BR/175/20/PL

23 Mead Lane Bognor Regis PO22 8AP

Change of use from Student Accommodation to 3 no. dwellings, comprising 1 no. one bed apartment, 1 no. two bedroom house and 1 no. three bedroom house (resubmission of application BR/99/20/PL).

Martyn White
Principal Conservation Officer,
Planning Services

NORTHERN ELEVATION

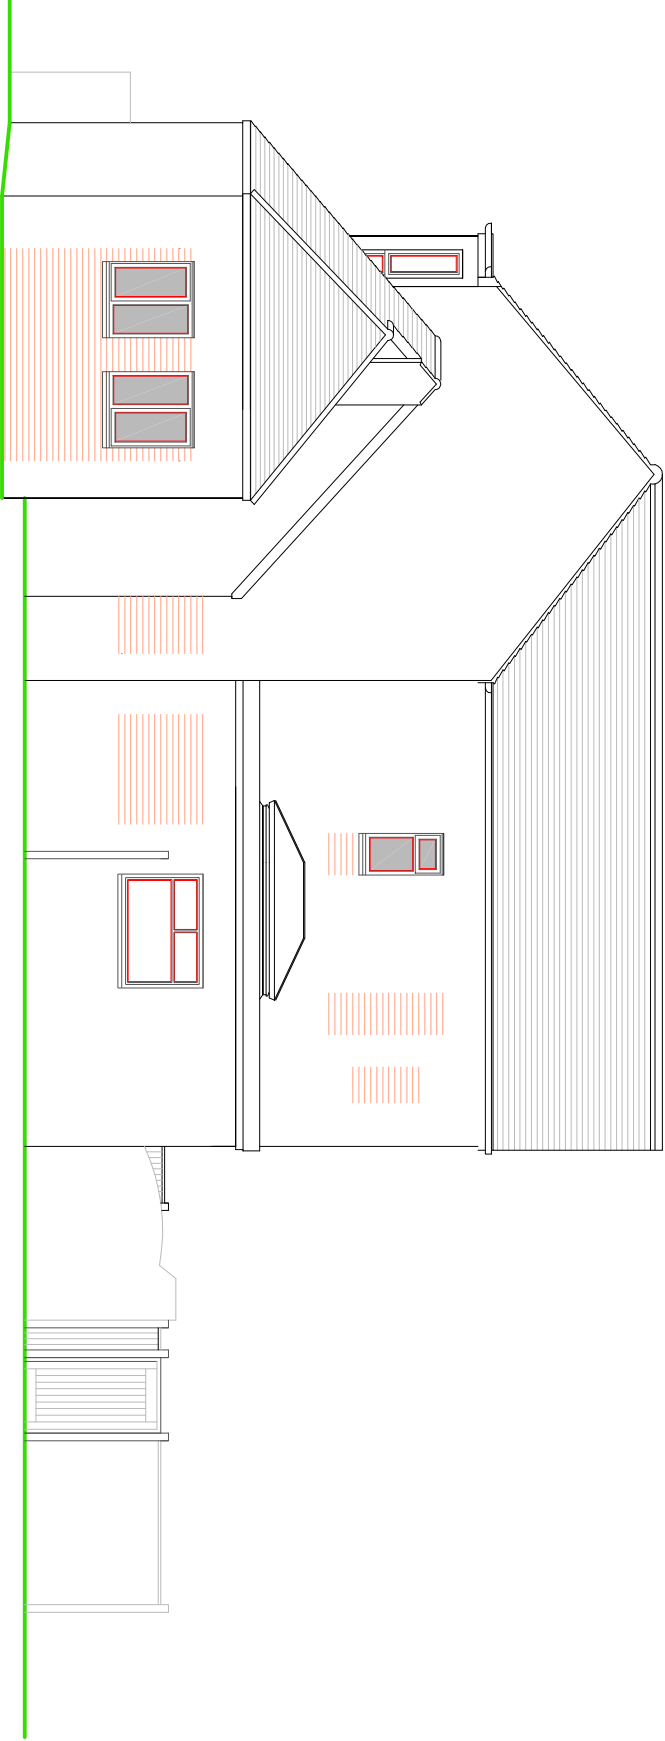
Whilst I am happy for the northern brick wall of the northern element of the building to be infilled, this will require some careful consideration, partly as a result of it being visible from the lane. This will require the materials to match in terms of colour and appearance to the existing and that the existing bond is followed. Details of the bond could be supplied to the council by way of condition, if minded to approved the application. I believe that it is positive to note that the attractive flint walling on the eastern elevation will not be altered in any way.

It is also considered important that the any new joinery which is visible form the public realm should be appropriate for the conservation area. For instance, the two new windows in the northern element of the building where it is suggested that they be timber side hung casements.

SOUTHERN ELEVATION

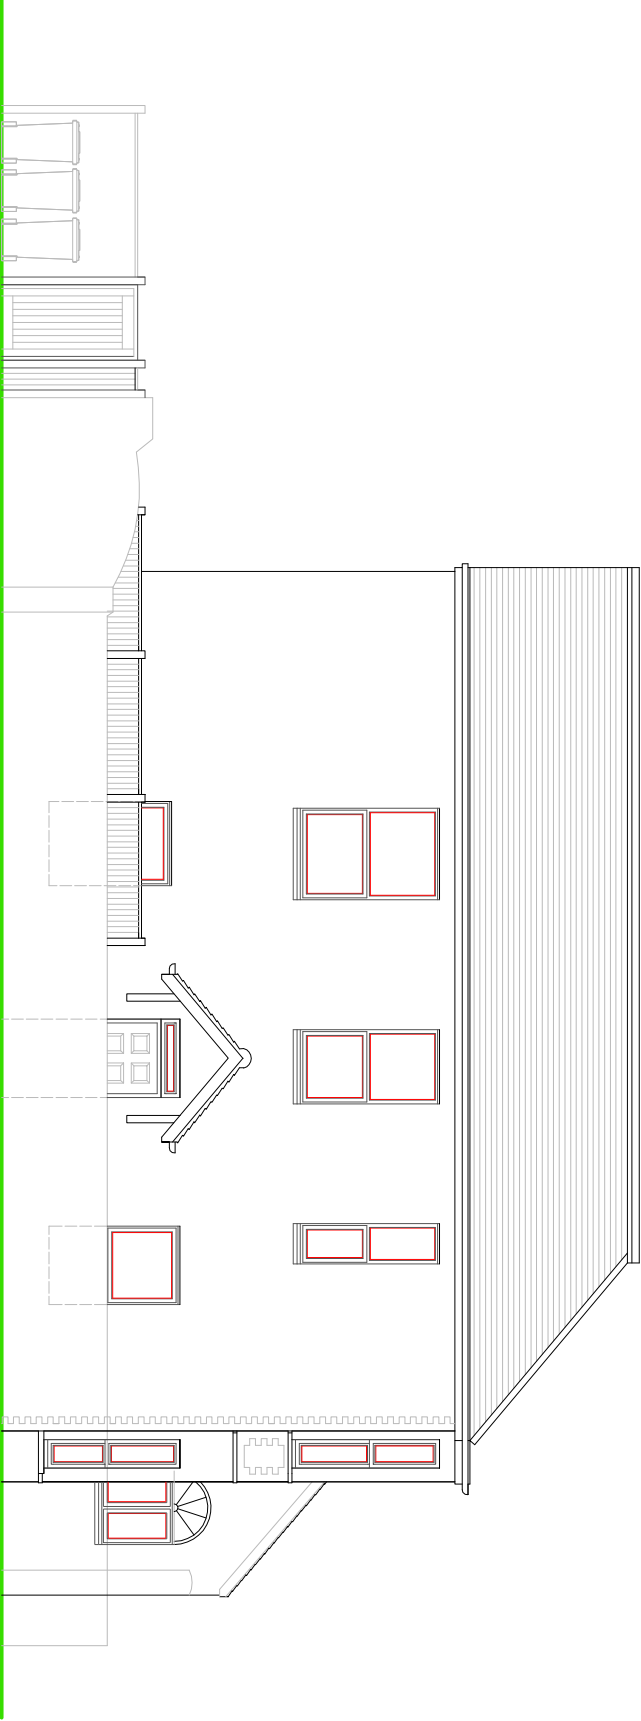
On reviewing the plans, I have noted that the proposed front doorway to Unit 3 seems to be shown as a window instead of a door on the proposed south elevation. This issue should be amended on the relevant drawings.
